Re: Planning Application 18/0902

Address: Longridge C of E Primary School Berry Lane Longridge PR3 3JA

Description: Installation of Securifor 2D Fencing including vehicular and pedestrian gates.

Proposed Fence & Gates - Location 1:200

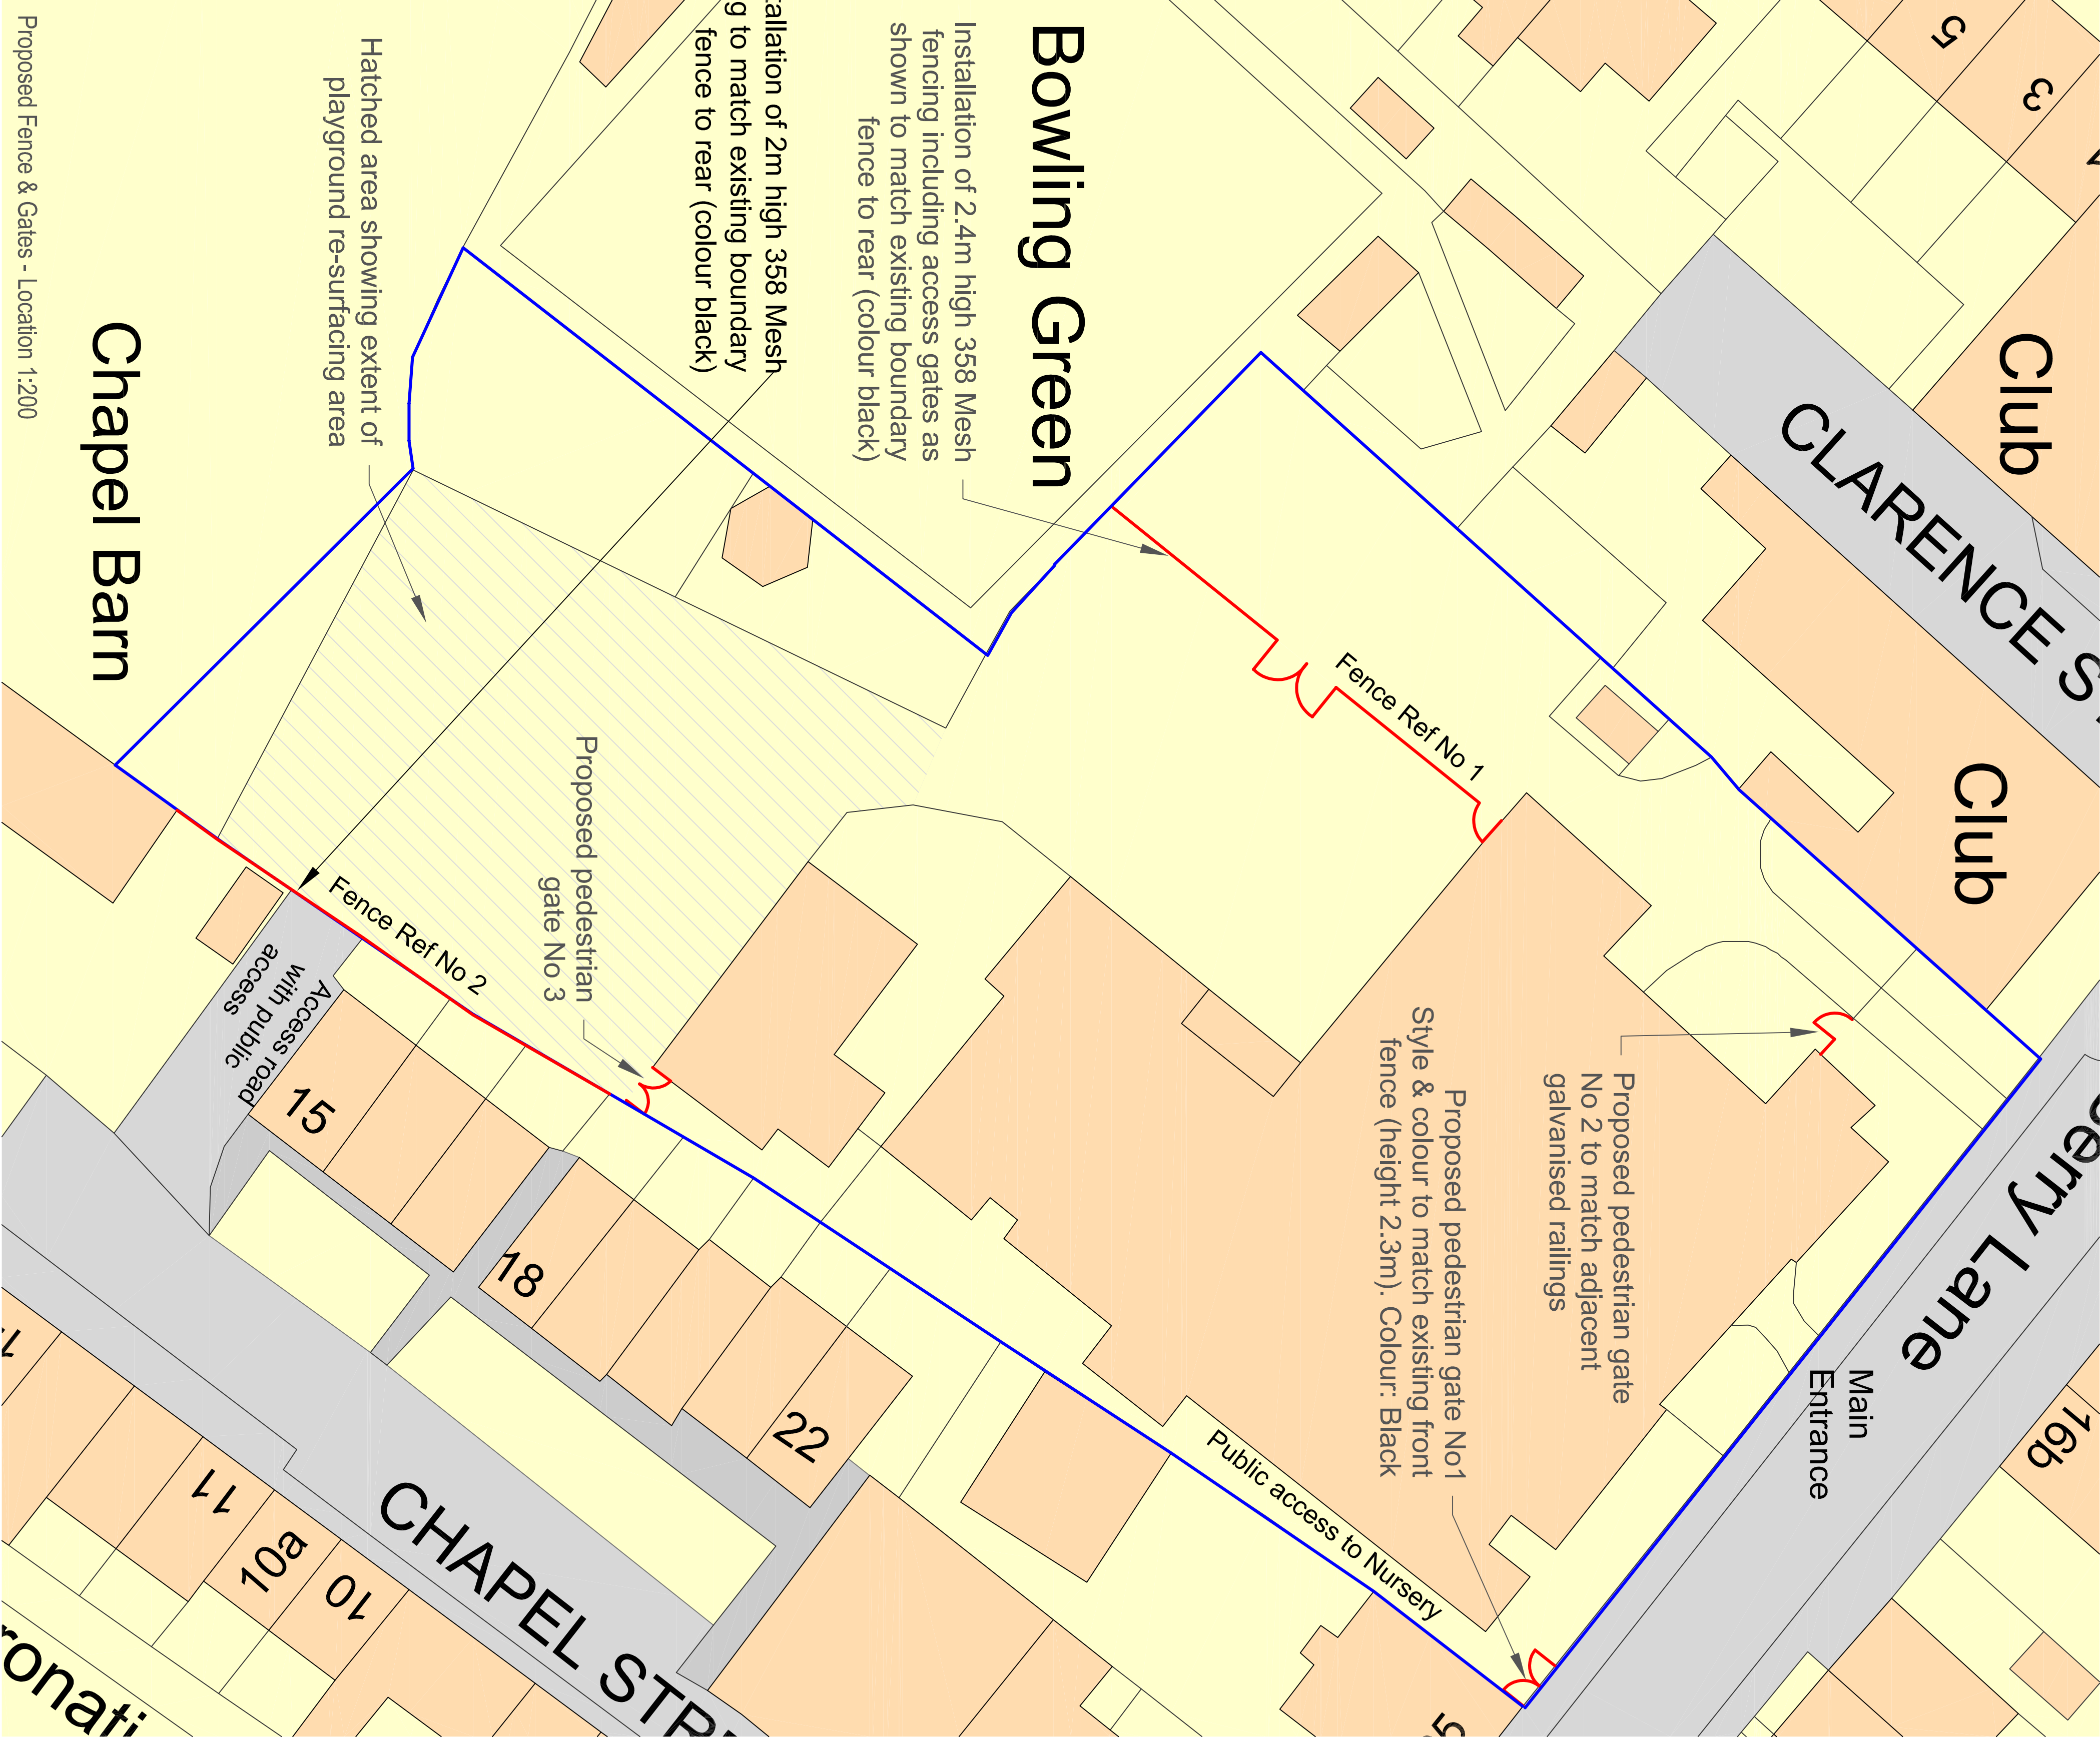
Care should be taken to ensure that all pedestrian entrances are constructed in line with guidance from The Department of Transport's document Inclusive Mobility. This would indicate a wheelchair user and an accompanying adult would require a width of 1500mm, wherever possible this width should be used as the minimum requirement for any pedestrian access.
